SANDSTONE CARE DEVELOPMENT PLAN

SITUATED IN SECTION 22, TOWNSHIP 13 SOUTH, RANGE 68 WEST OF THE 6TH P.M.,
CITY OF COLORADO SPRINGS, COUNTY OF EL PASO, STATE OF COLORADO

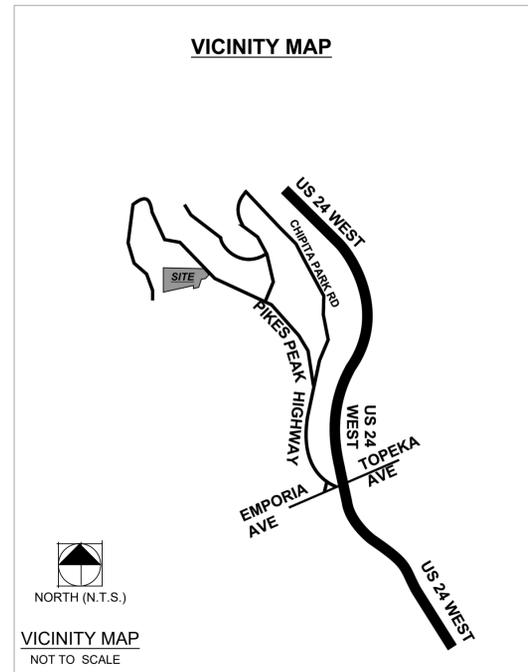
Please revise ADA note:
The parties responsible for this plan have familiarized themselves with all current accessibility criteria and specifications and the proposed plan reflects all site elements required by the applicable ADA design standards and guidelines as published by the United States Department of Justice. Approval of this plan by El Paso County does not assure compliance with the ADA or any regulations or guidelines enacted or promulgated under or with respect to such laws.

Include actual building height

Separate into building coverage and total impervious coverage

Include signature block for the Planning and Community Development Director a minimum of 1 inch by 2 inches

Please update sheet numbers

Add PCD File #

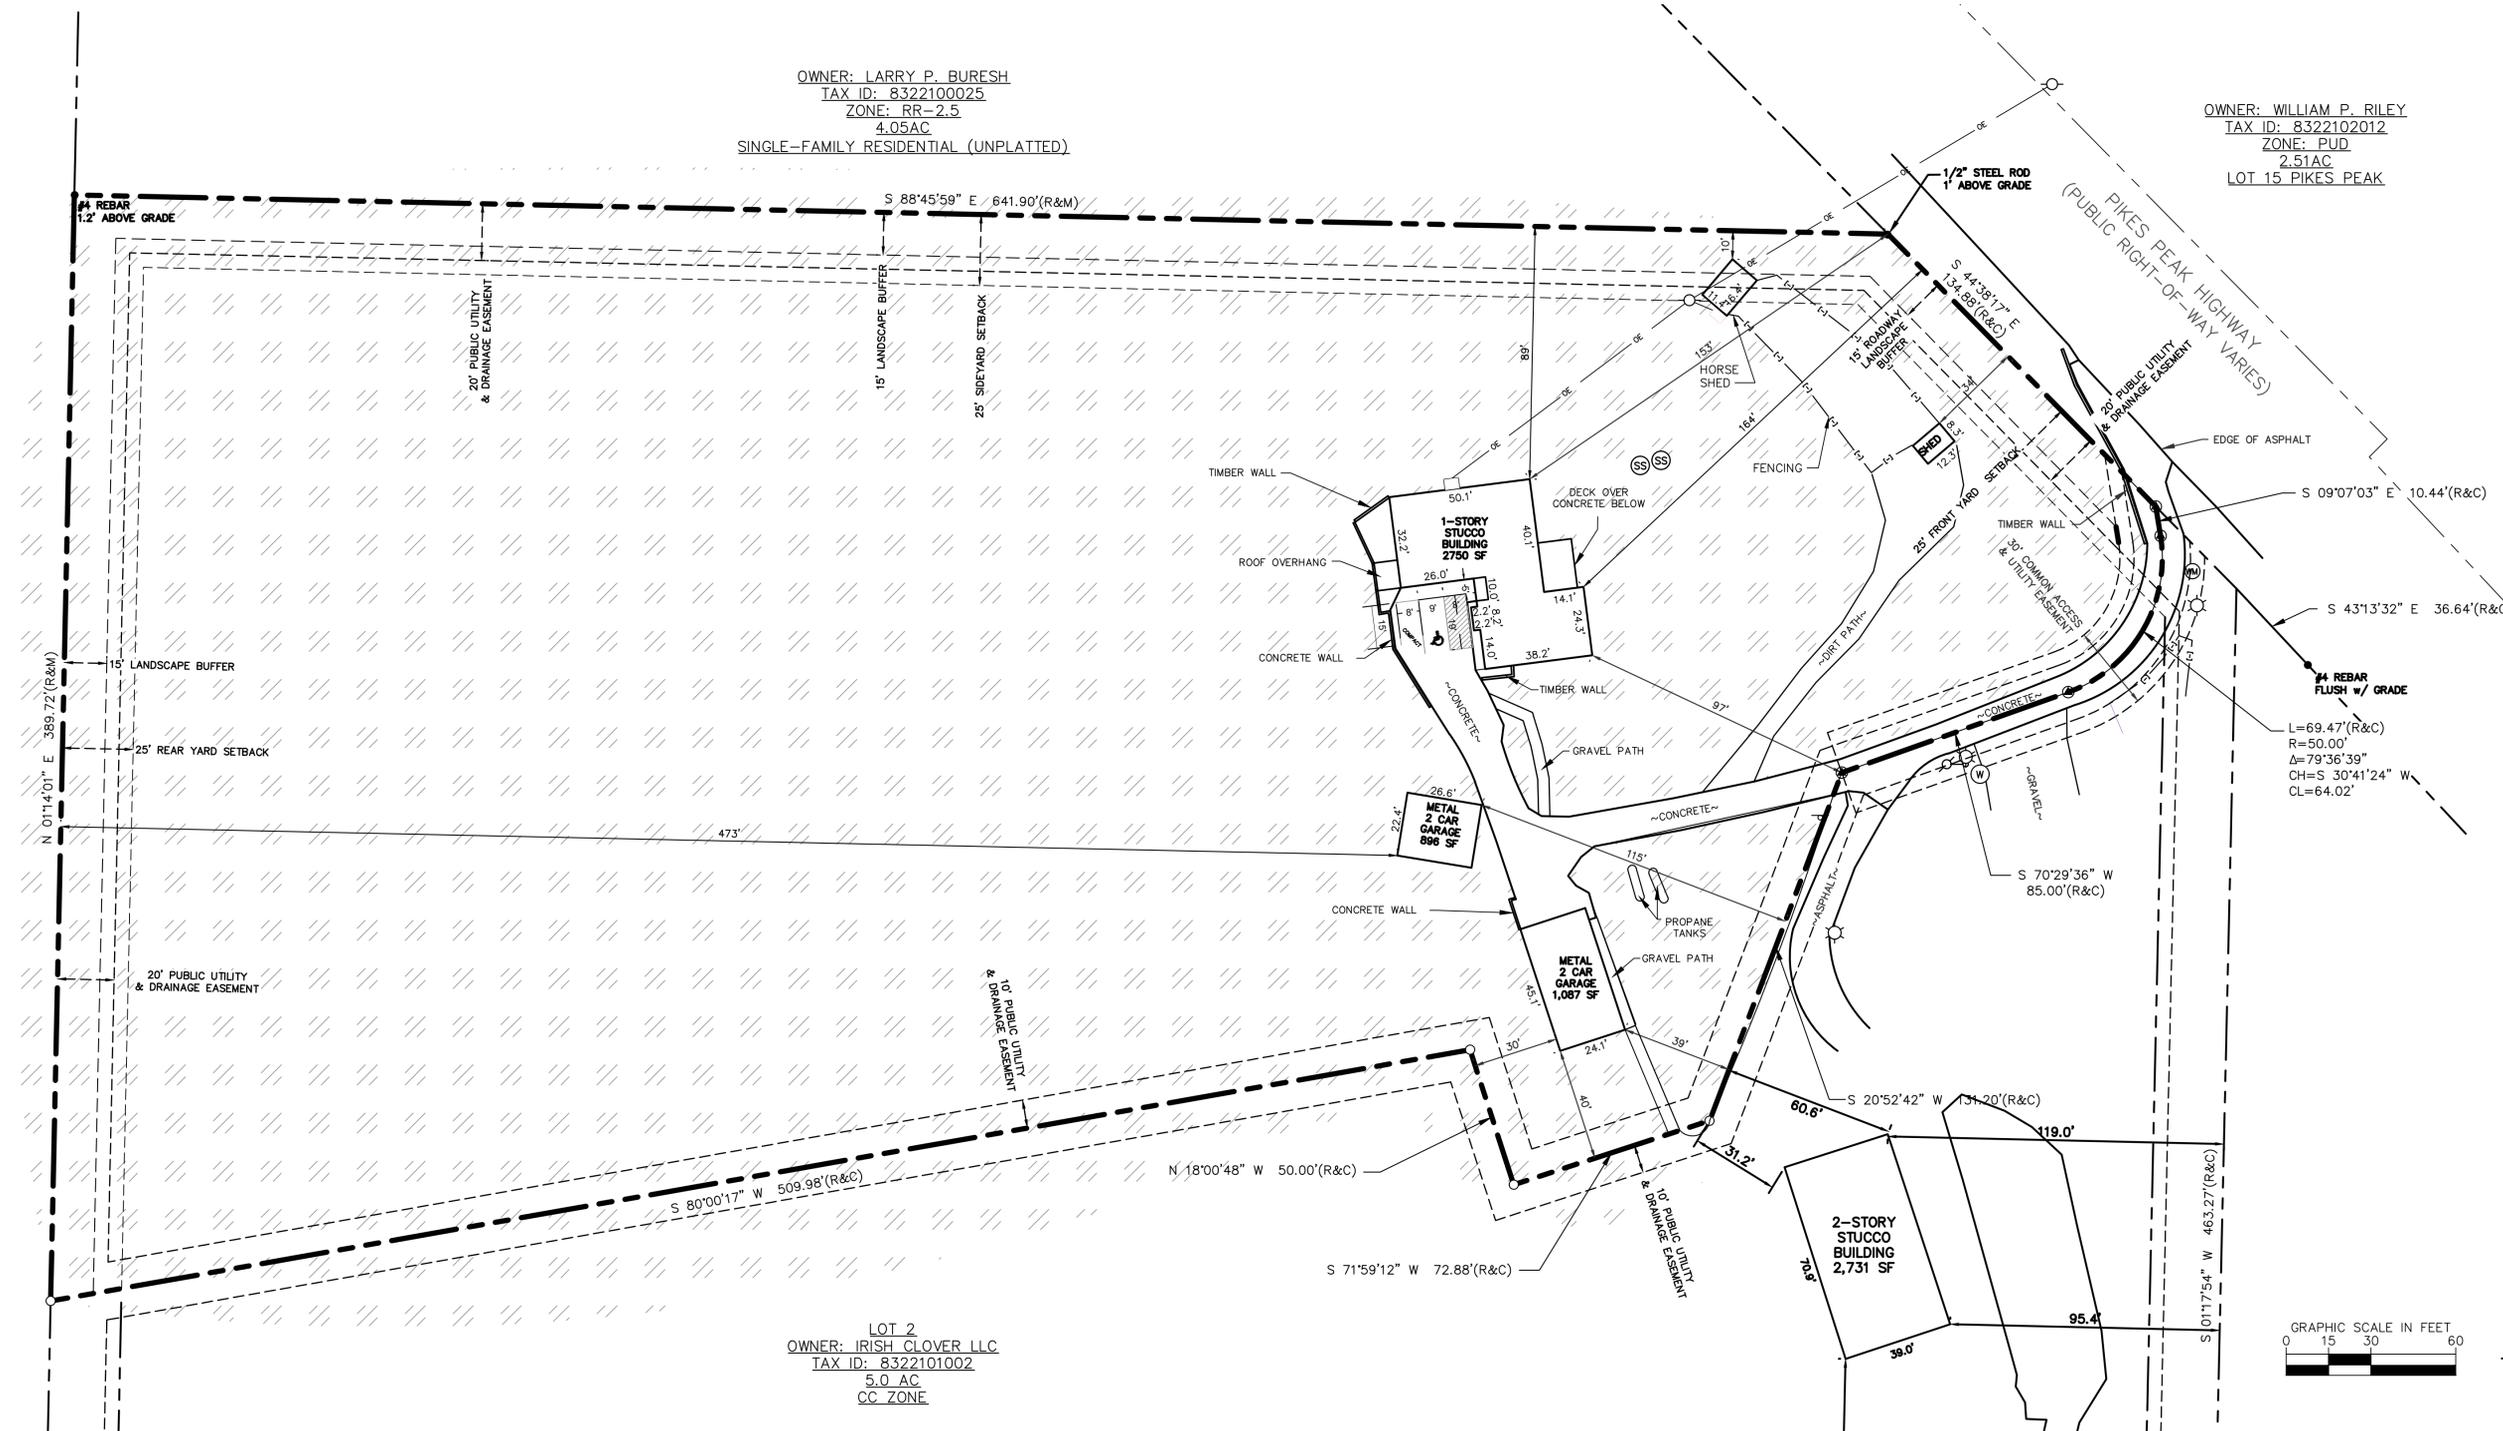
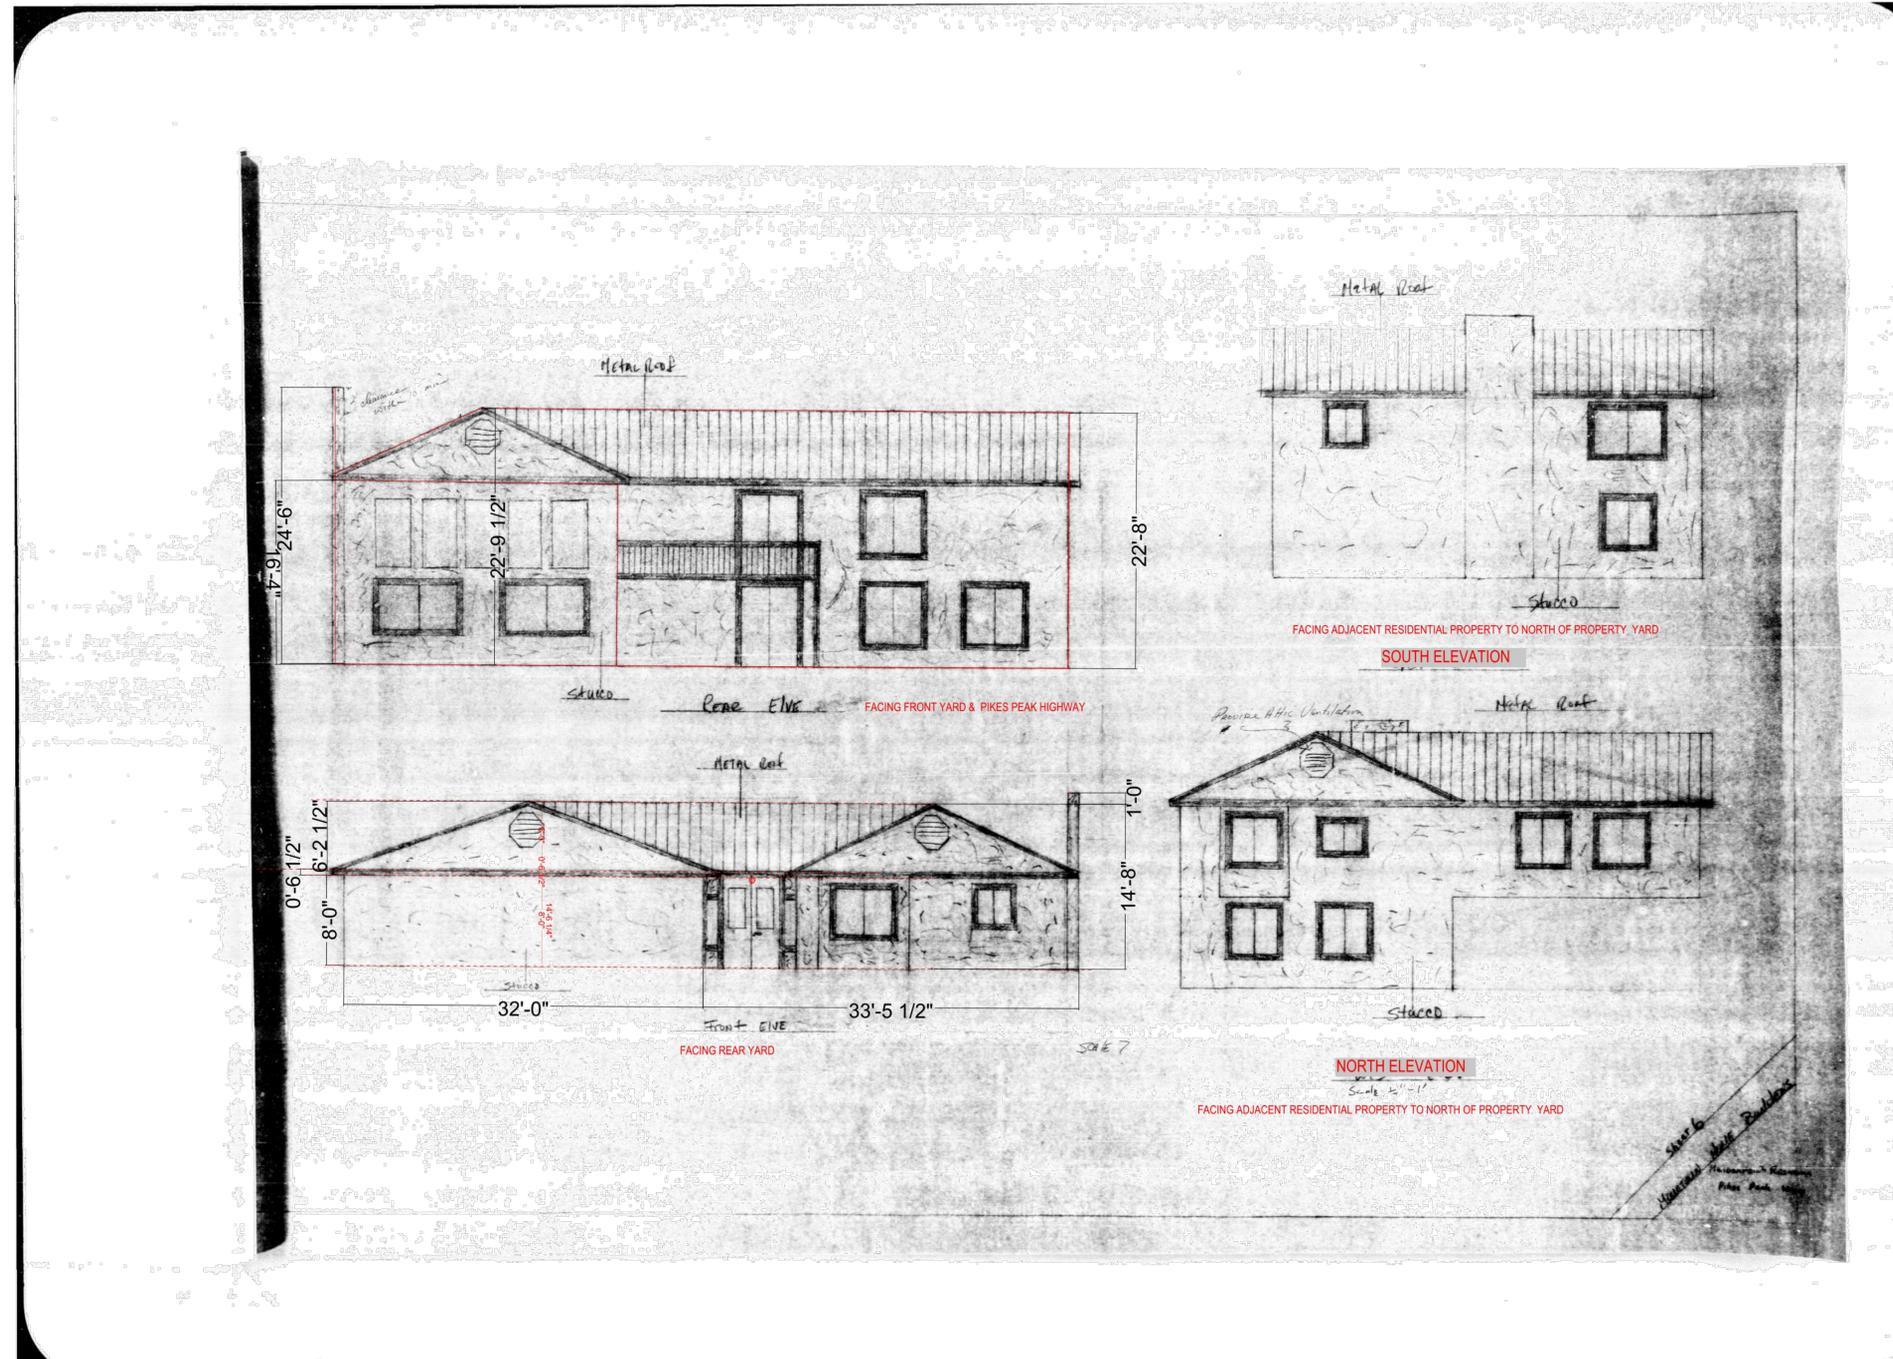
Please add a note or label all structures/ driveways
that are existing. Label anything new as proposed.

Include Location of existing and proposed water and wastewater infrastructure, including well and septic locations, if applicable; Location of all existing and proposed utility lines and associated infrastructure
